From: Laura Gibbons <Laura.Gibbons@arun.gov.uk>
Sent: 19 October 2021 09:29
To: Planning.Responses <Planning.Responses@arun.gov.uk>
Cc: Simon Davis <Simon.Davis@arun.gov.uk>
Subject: RE: Planning Consultation on: A/212/21/DOC

Site Address: Merry England Dappers Lane Angmering BN16 4EN

Description of Works: Approval of details reserved by condition imposed under A/91/18/PL relating to condition 4-surface water drainage.

Formpave permeable block paving private parking area construction

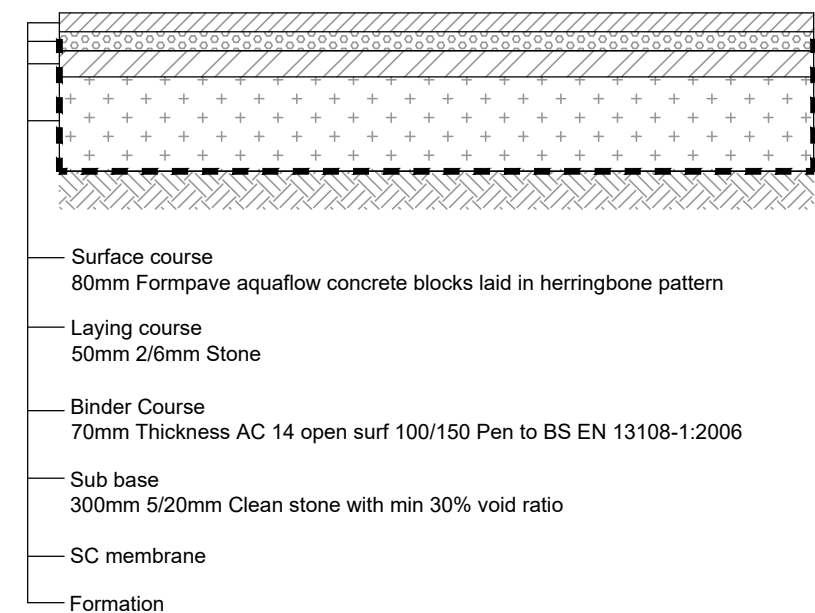
- Please can the applicant submit revised construction detail drawings which show the construction of the permeable block paving in place of the resin bound paving previously proposed.
- It appears that diffusers are proposed, these should be labelled with invert level.
- Formation level of permeable paving should be clearly labelled.
- Please can the applicant confirm whether any further changes beyond surface type and the use of diffusers are included within the latest proposals.
